# Rezoning Transportation Analysis

Petition Number: 2023-023

## Revision Log:

Date	Description
7-26-23	First Review (IW)
11-27-23	Second Review (DR)
2-21-24	Third Review (ME)
3-20-24	Fourth Review (NK)

SHEET NUMBER: RZ2-00

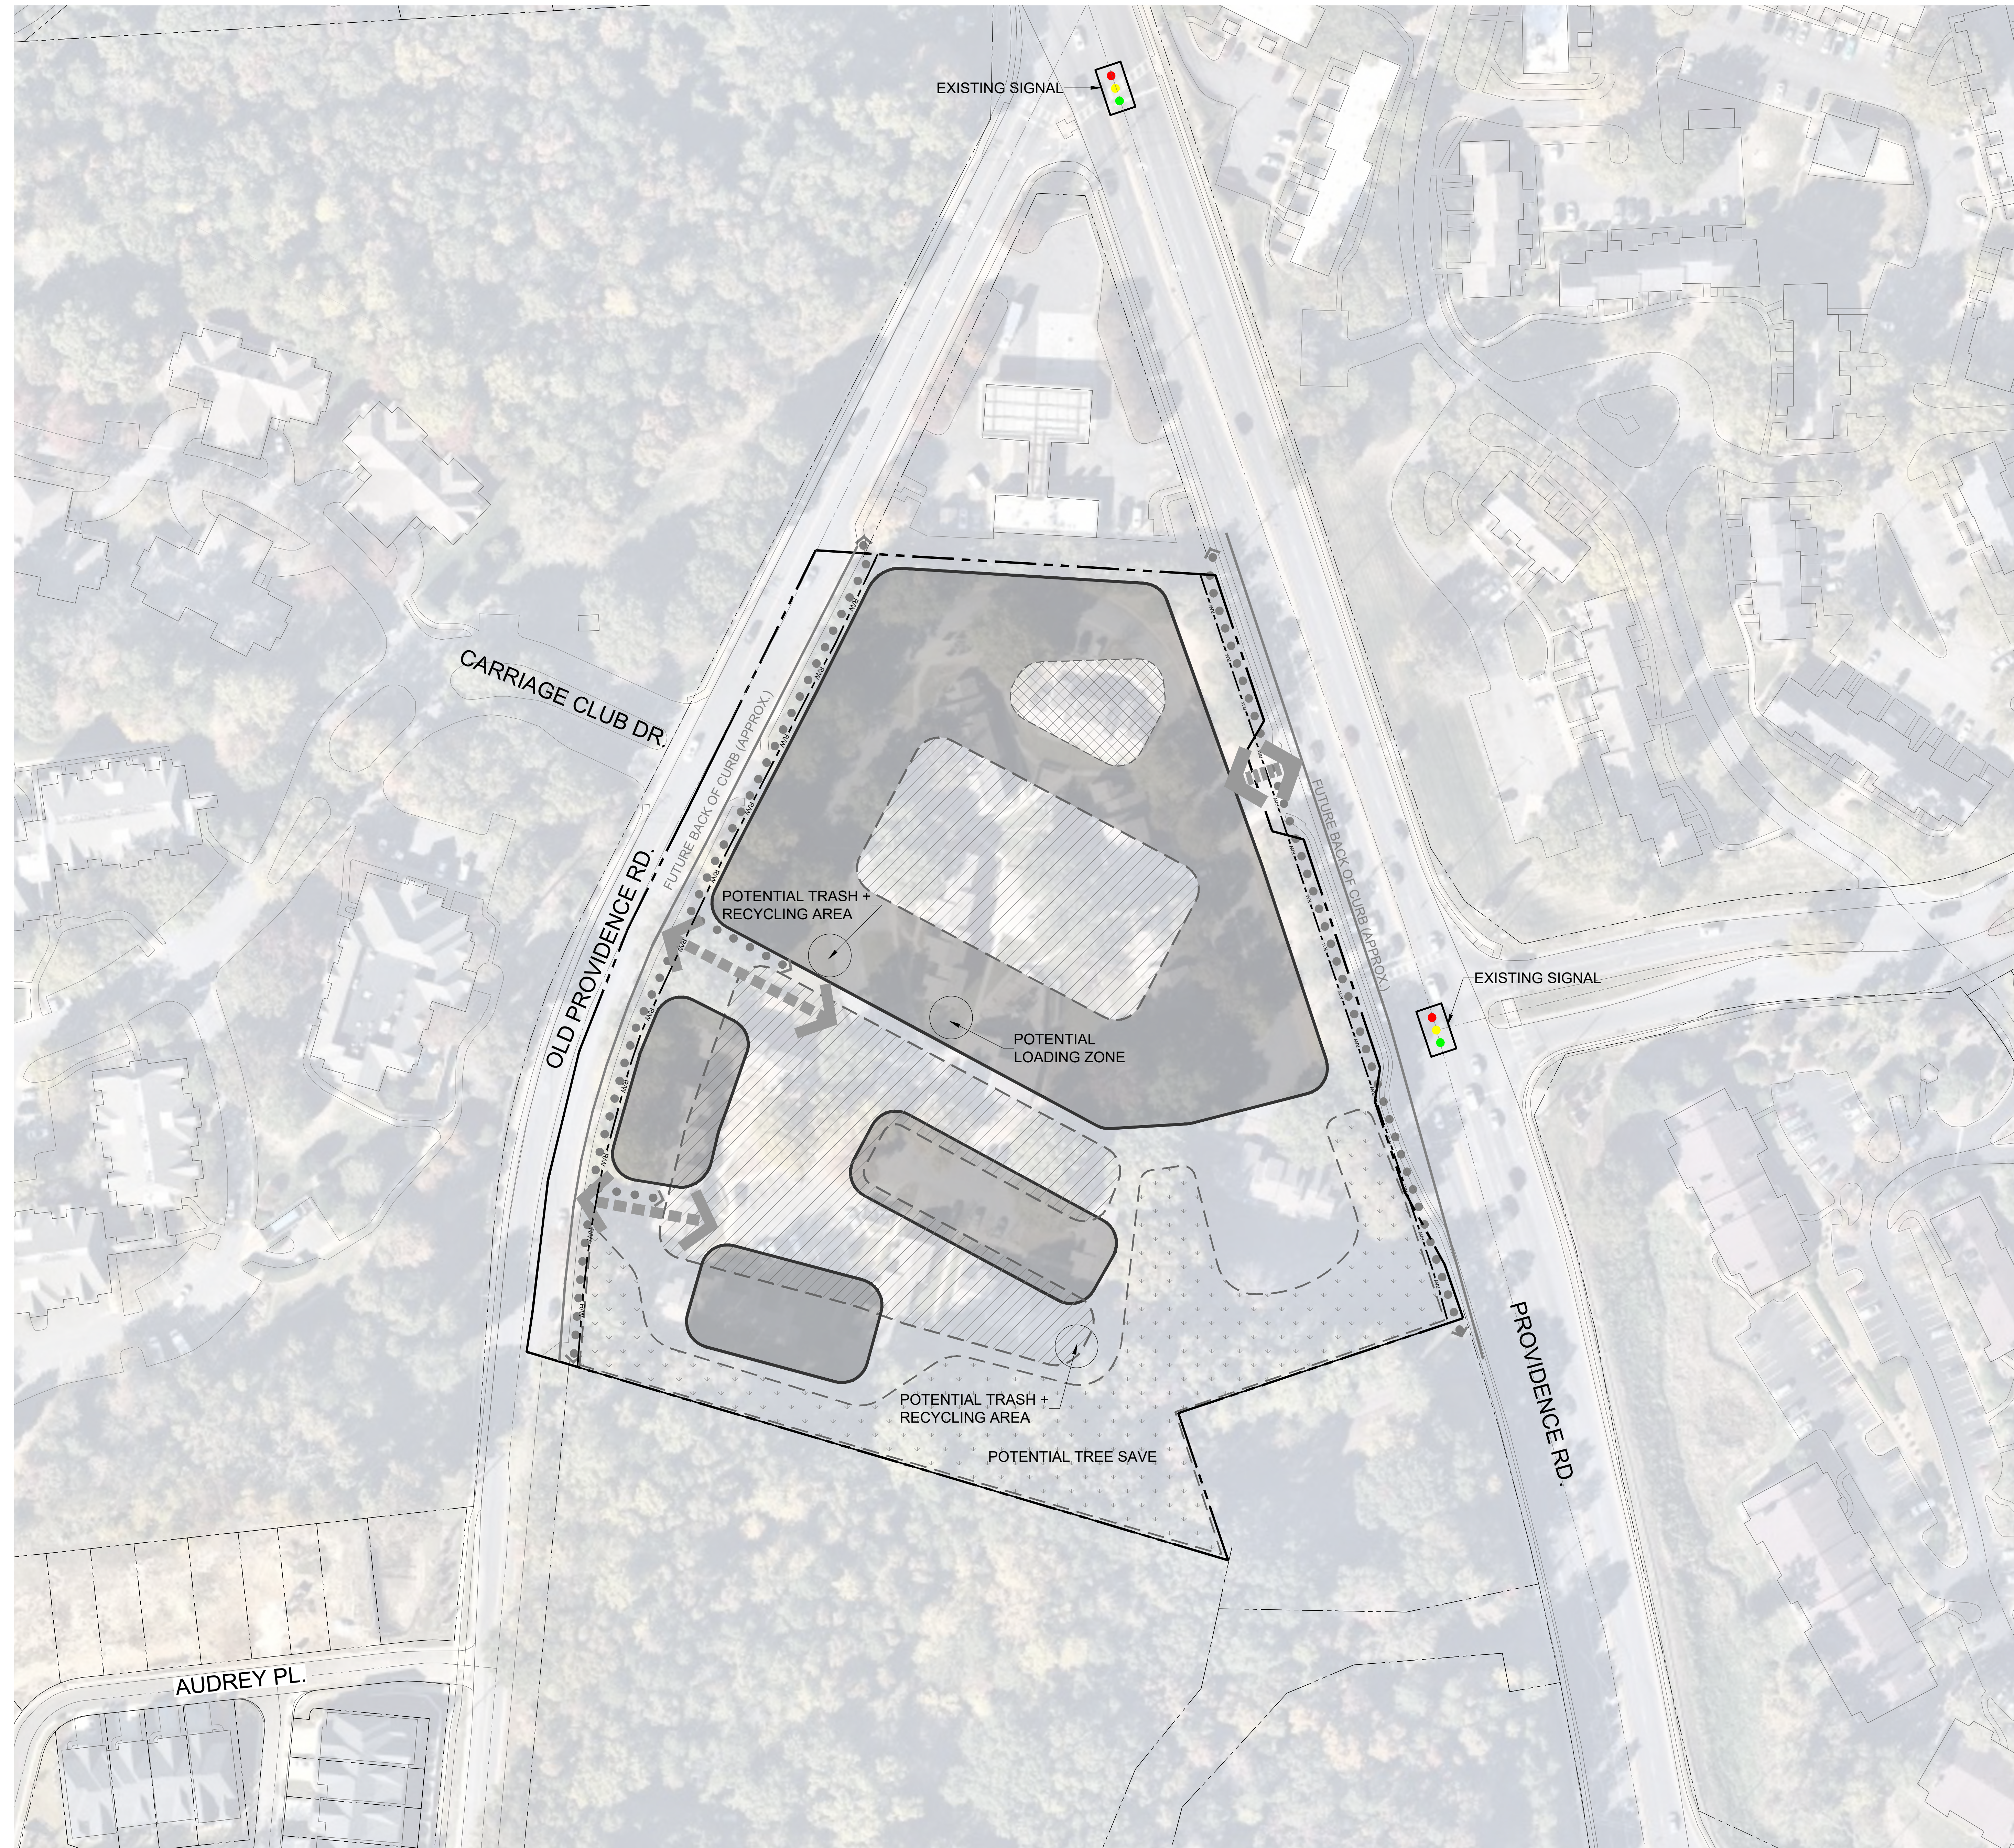
Label and dimension the curb and gutter from the centerline for each road on the site plan.

~~**New Comment 11.27.23:** Section C public street network sidewalk width does not match the conditional note. Revise Section C to have an 8' sidewalk like the conditional notes for the Old Providence Road section.~~
